From: Anita Gardner
Sent: 28 February 2018 12:51
To: Karen Parsons
Subject: FW: FW: New Barn, Ryebank Farm, Climping

I am still awaiting the revised written comments of the Conservation officer and I am not in the office the rest of this week. I would therefore be grateful for your agreement to a further extension of time on the application until 09-03-2018.

Subject: Ryebank Barn, Climping

RE: New Barn, Ryebank Farm, Climping

Client Mr J. Baird
Job Title Ryebank Farm, Climping, Littlehampton, West Sussex
Drawing Title Proposed Drawing Roof Plan, North & East Elevations and Cart Barn North West Elevation 1/100 @ A1

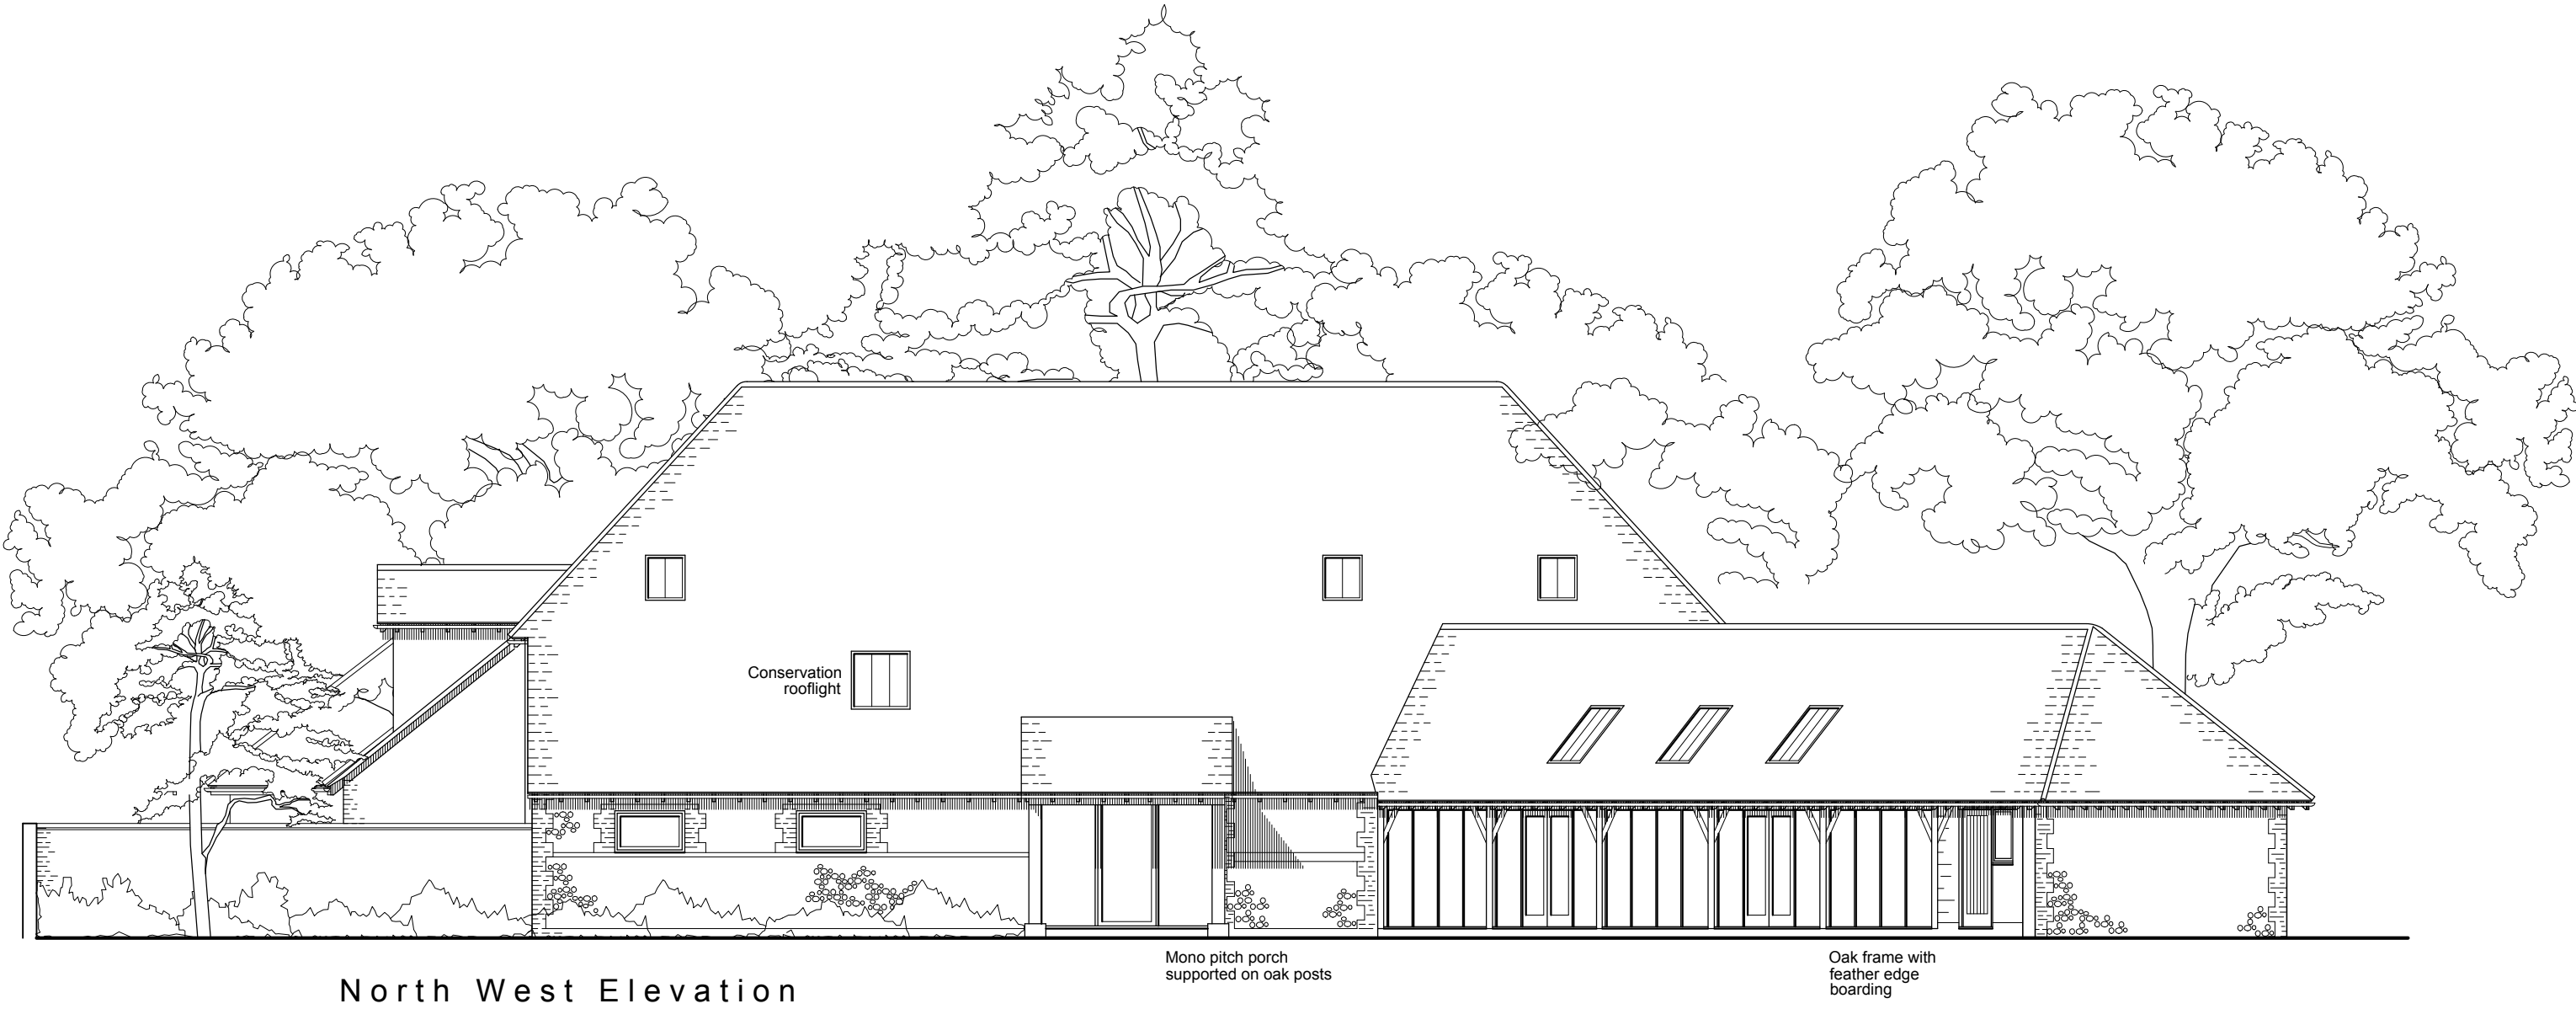
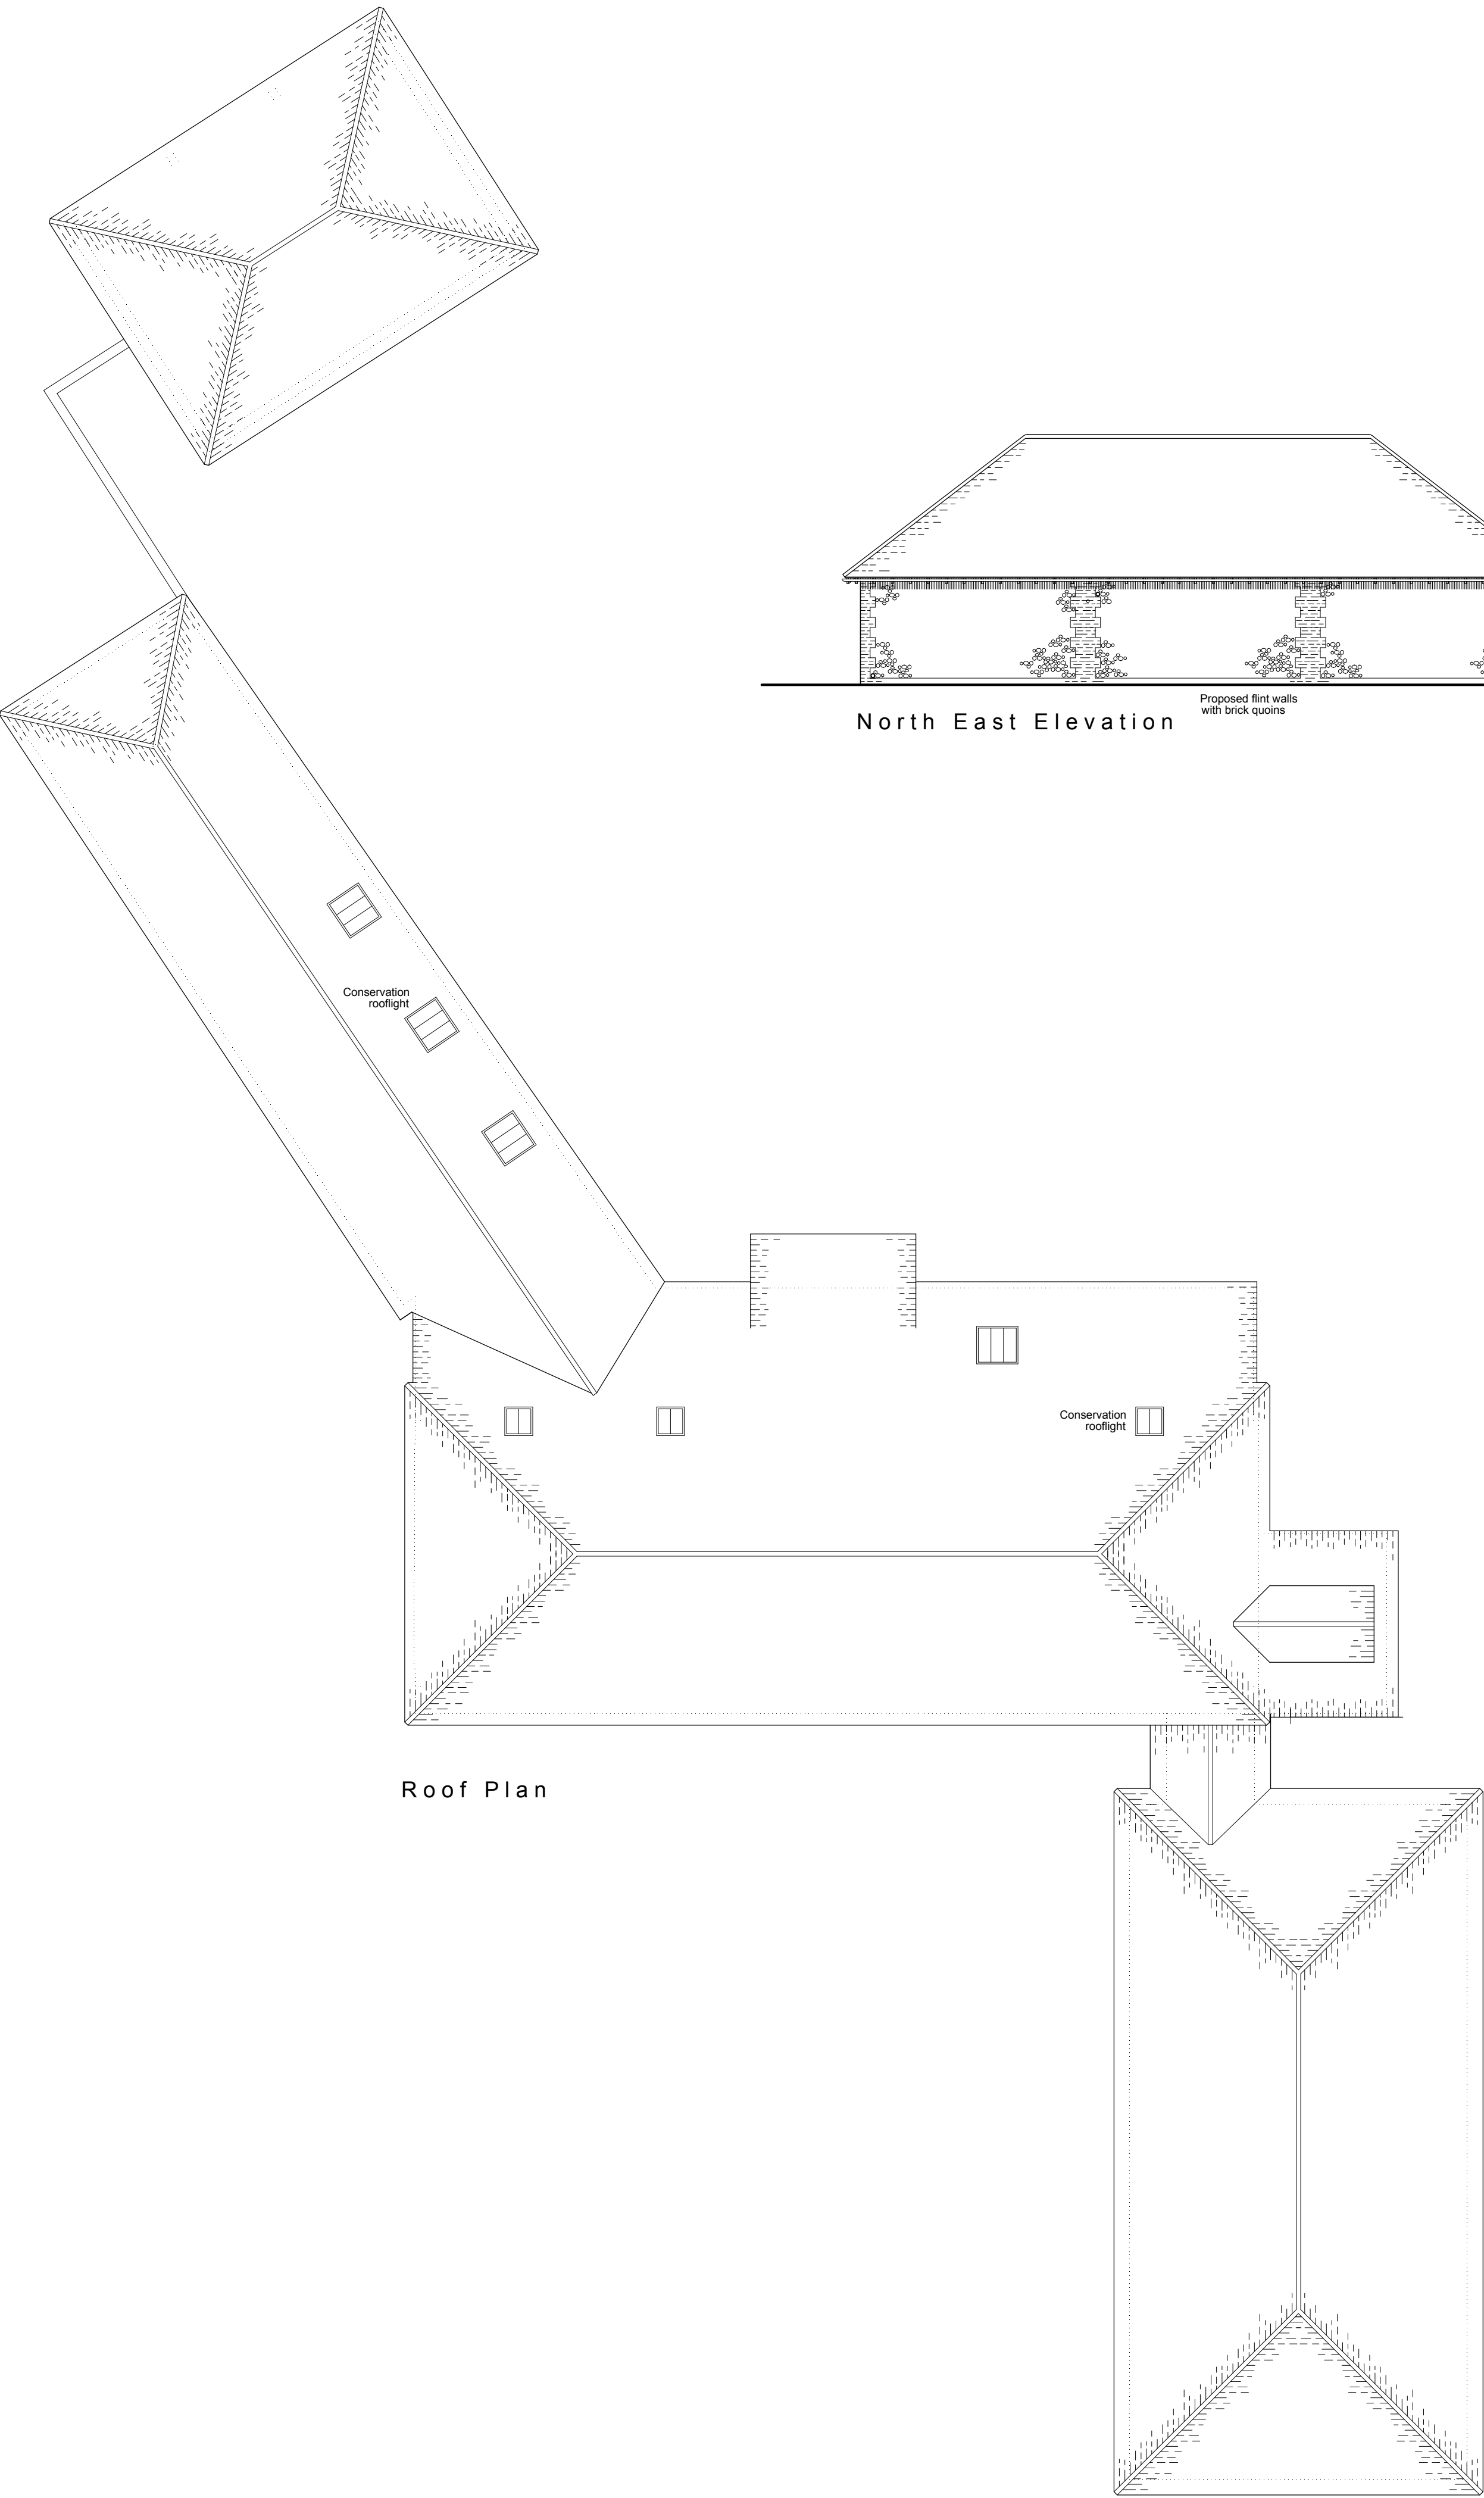
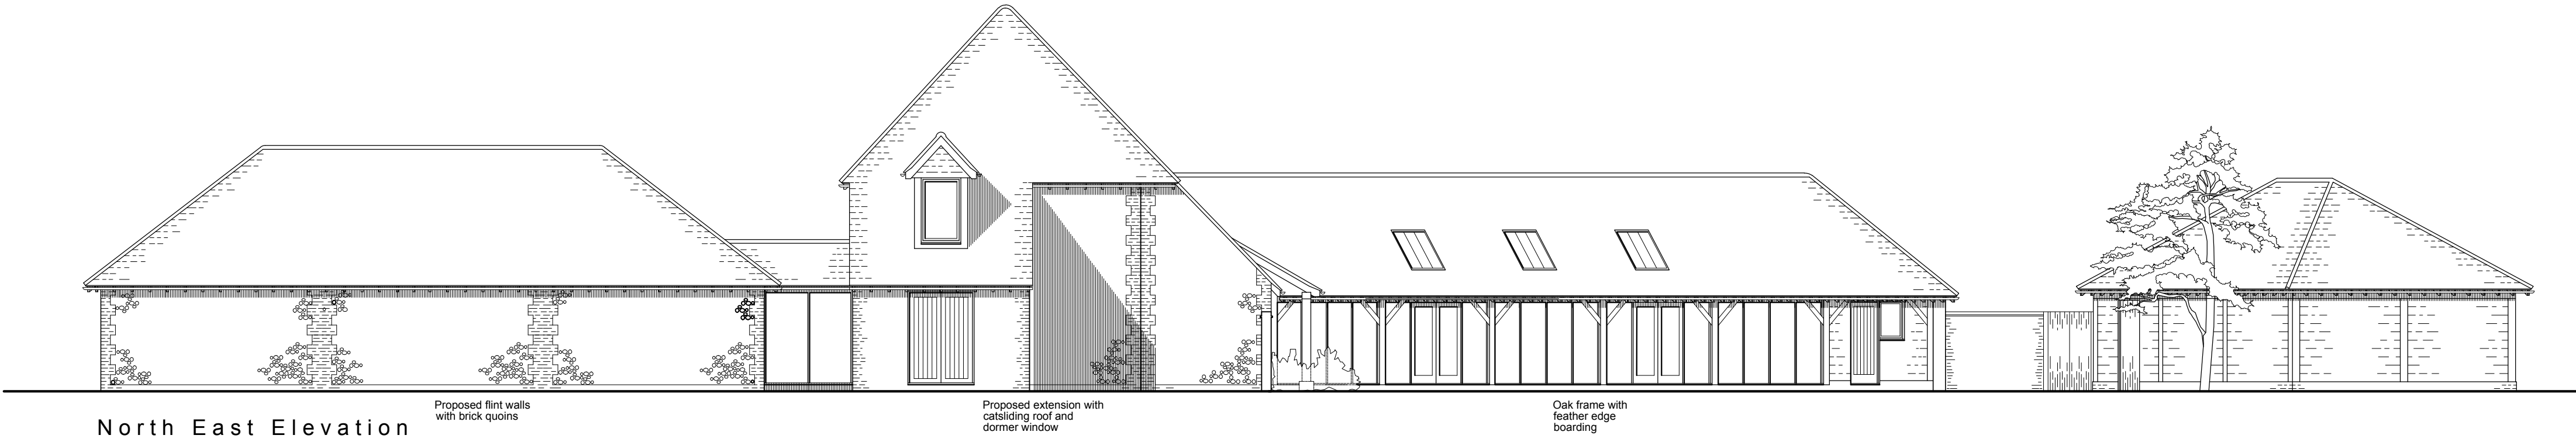
- Roof lights to be flipped to the NW side on the open range and to be substantially omitted from the main barn. Possibly with an enlargement of the first floor window on the SE elevation – where it cuts through new fabric.

Other minor observations relate to the thin windows in the timber cladding of the south elevation. We wonder if these three windows could be rationalized to appear less abstract. We would also prefer to see the (top left) roof light in the north elevation either removed or moved. It seems quite close to the corner.
